MIDDLE HARBOUR – WILLOUGHBY PROGRESS ASSOCIATION

30th May, 2013

Re : Albert Ave / Thomas Street, Chatswood – Part 3A Development Proposal

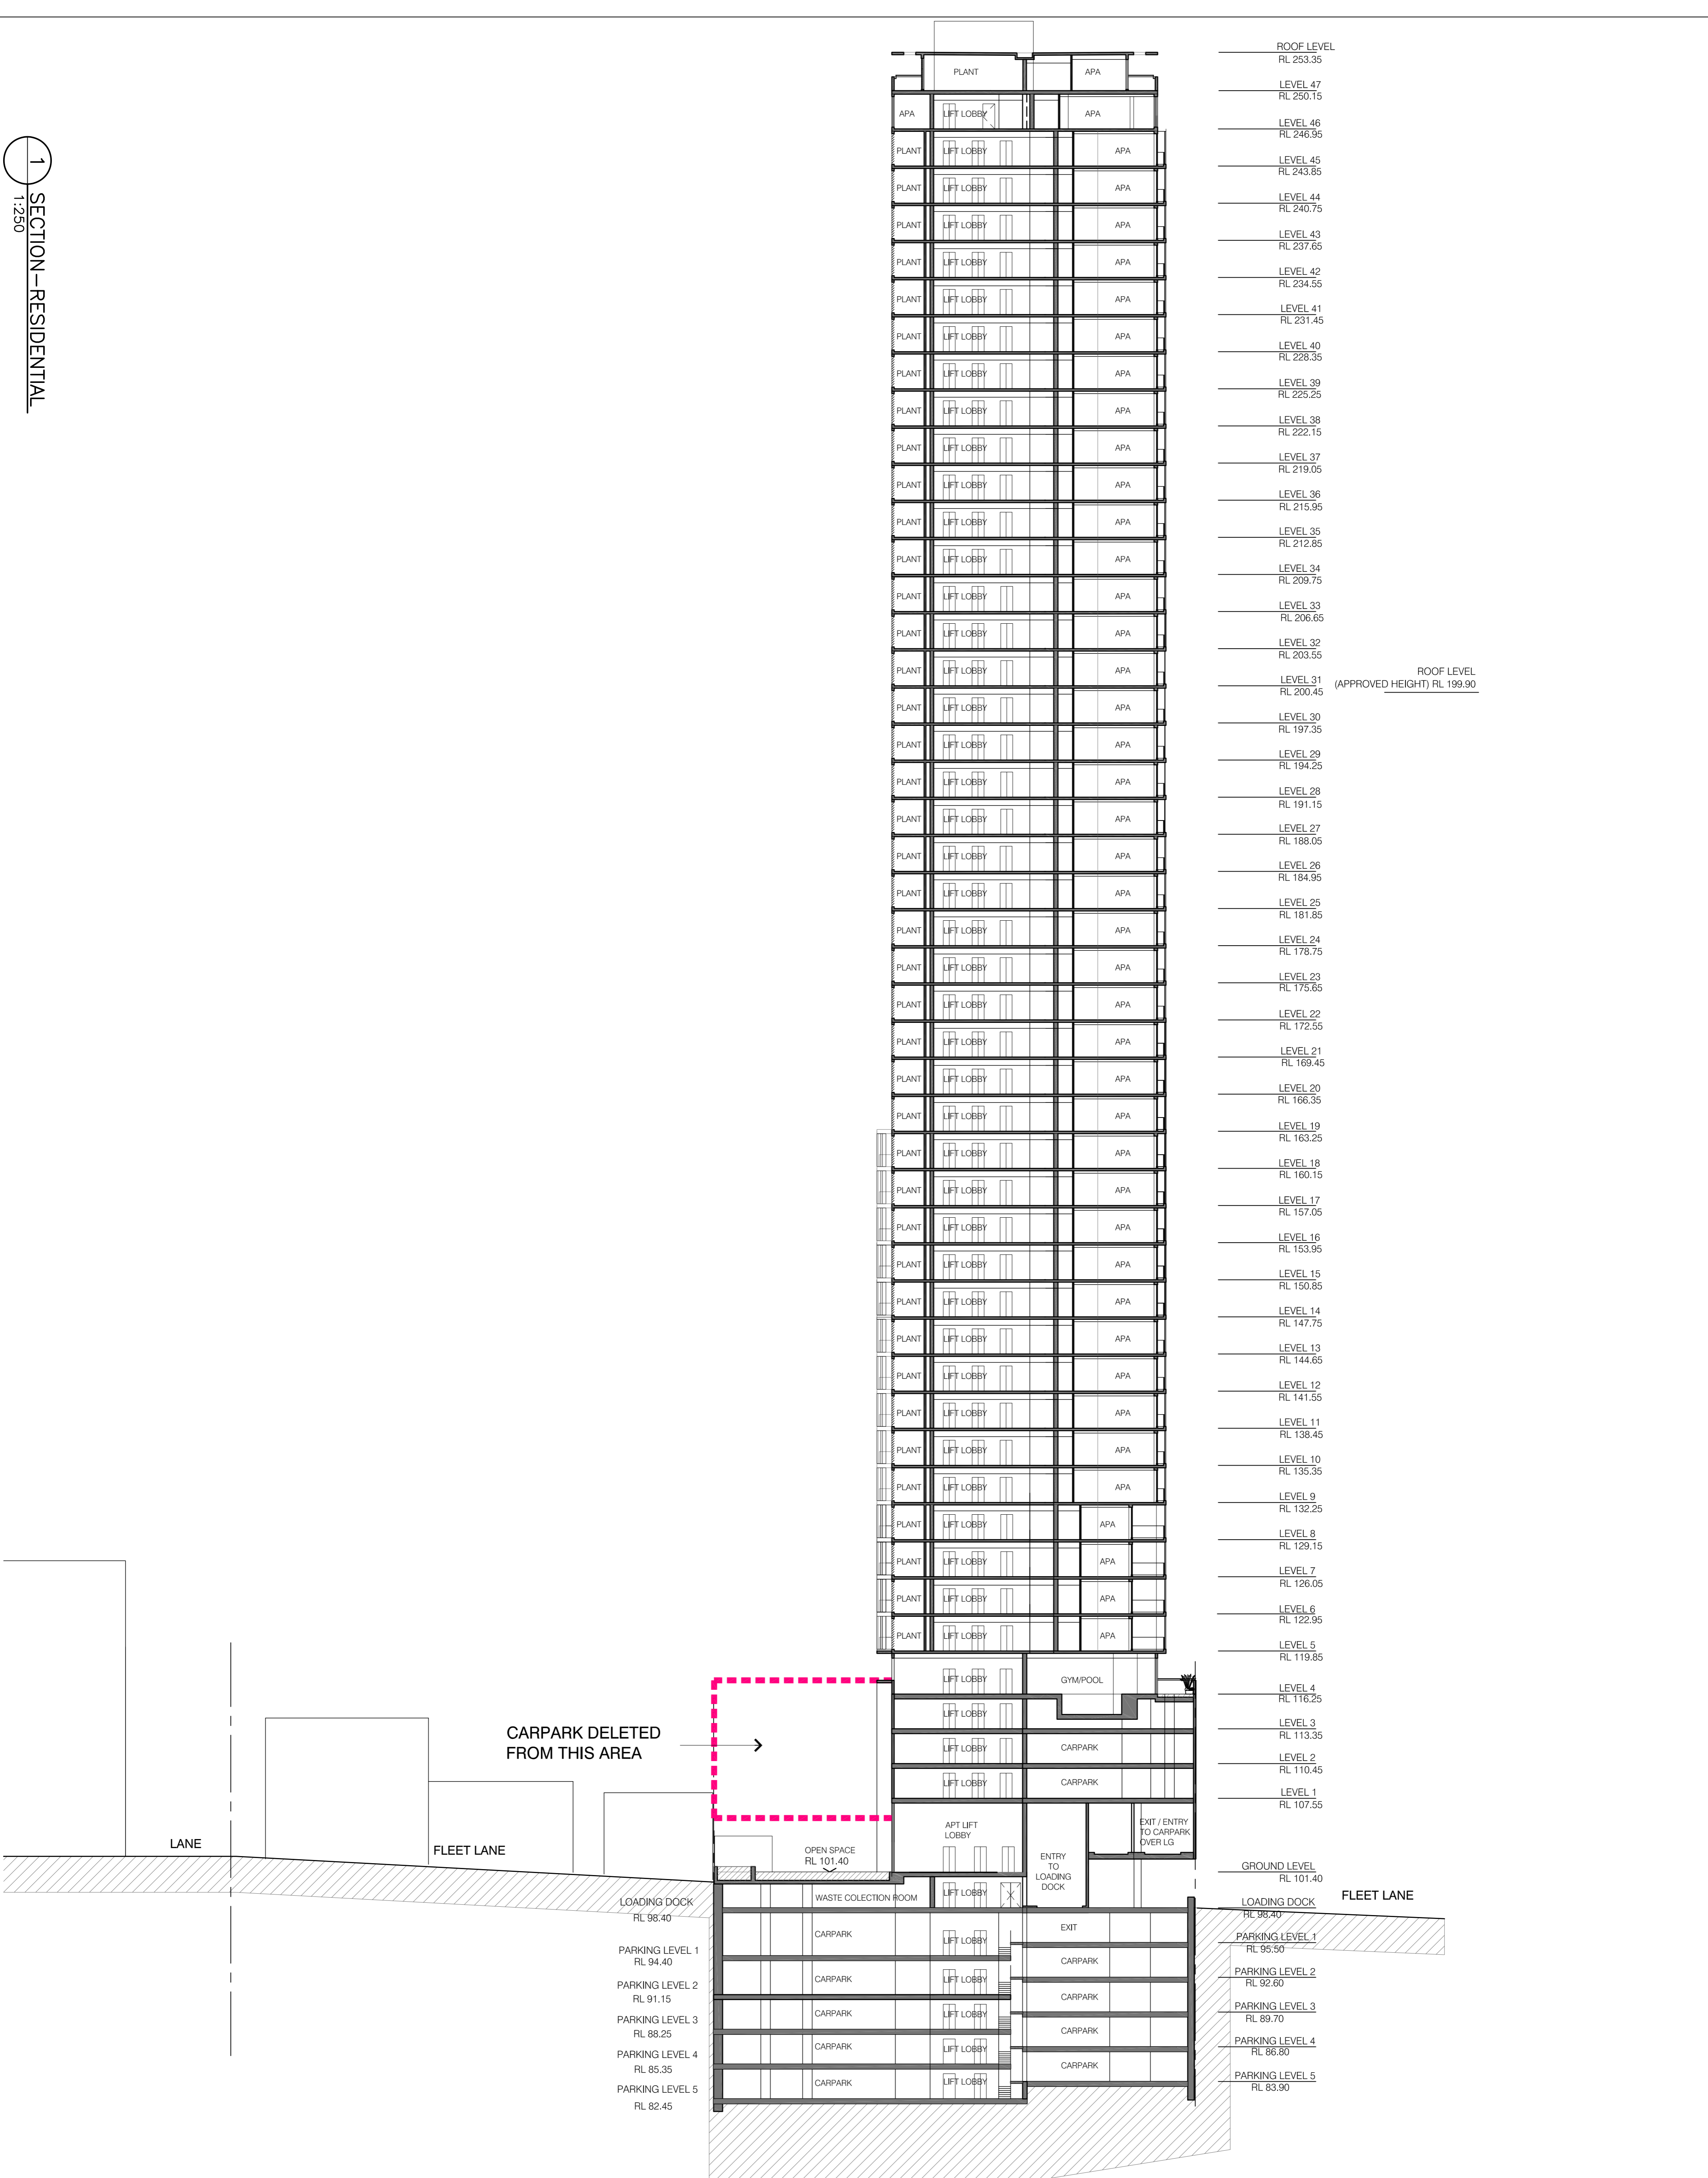
Meriton has now submitted **Modification 6** seeking to increase the height and scope of the development, in each of the tower blocks, which would see the 27 storey block increase to 37 storeys with 353 serviced apartments and the other from 30 storeys to 47 storeys with 353 residential units, the respective heights increasing to RL 221.95 and RL 253.35.

2. The proposal would increase the serviced apartment from 302 to 356 serviced and residential units from 233 to 353 and takes no account of overshadowing of neighbouring residents to the South, the impact on local infrastructure, schools, child care etc.
